# KITTITAS COUNTY FIRE MARSHAL'S OFFICE

July 1, 2010

Re: Jones (BL-10-00025)

BOUNDARY LINE ADJUSTMENT
PREPARED FOR
GARY JONES
A PORTION OF THE NW 1/4 OF SECTION 34,
TOWNSHIP 18 NORTH, RANGE 18 EAST, W.M.
KITITITAS COUNTY, WASHINGTON

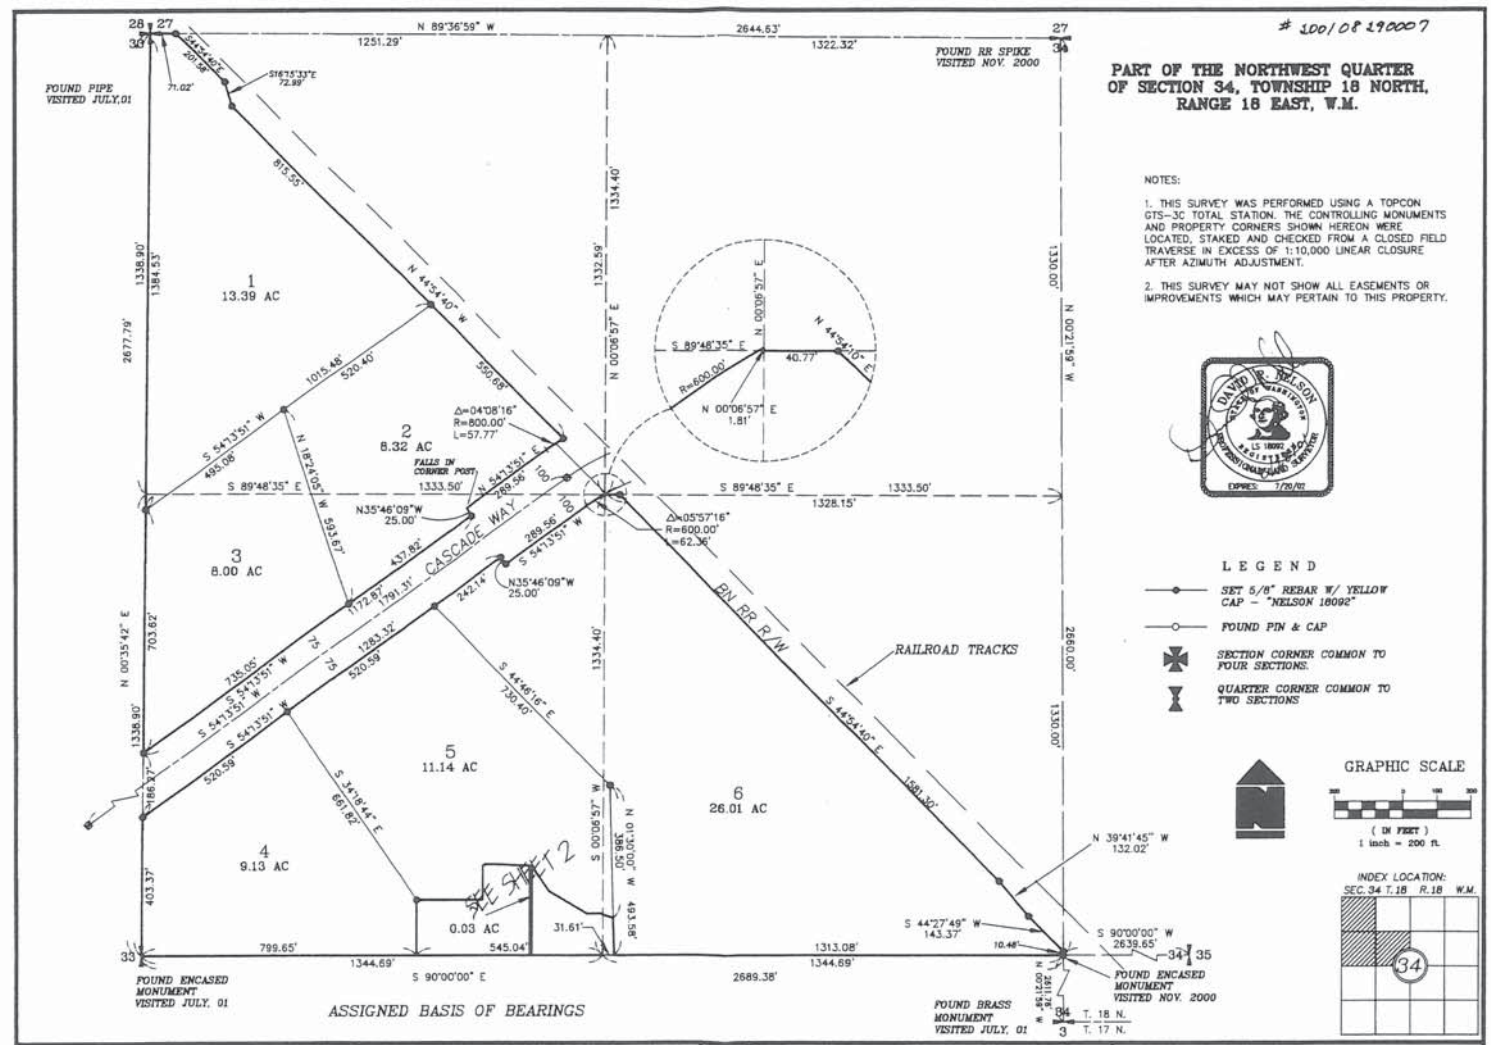
- Ensure that boundary line adjustments do not infringe upon existing structures, to include propane tanks, etc.
- Creation of any additional roads or access must comply with the International Fire Code.
- All future development must comply with the International Fire Code.
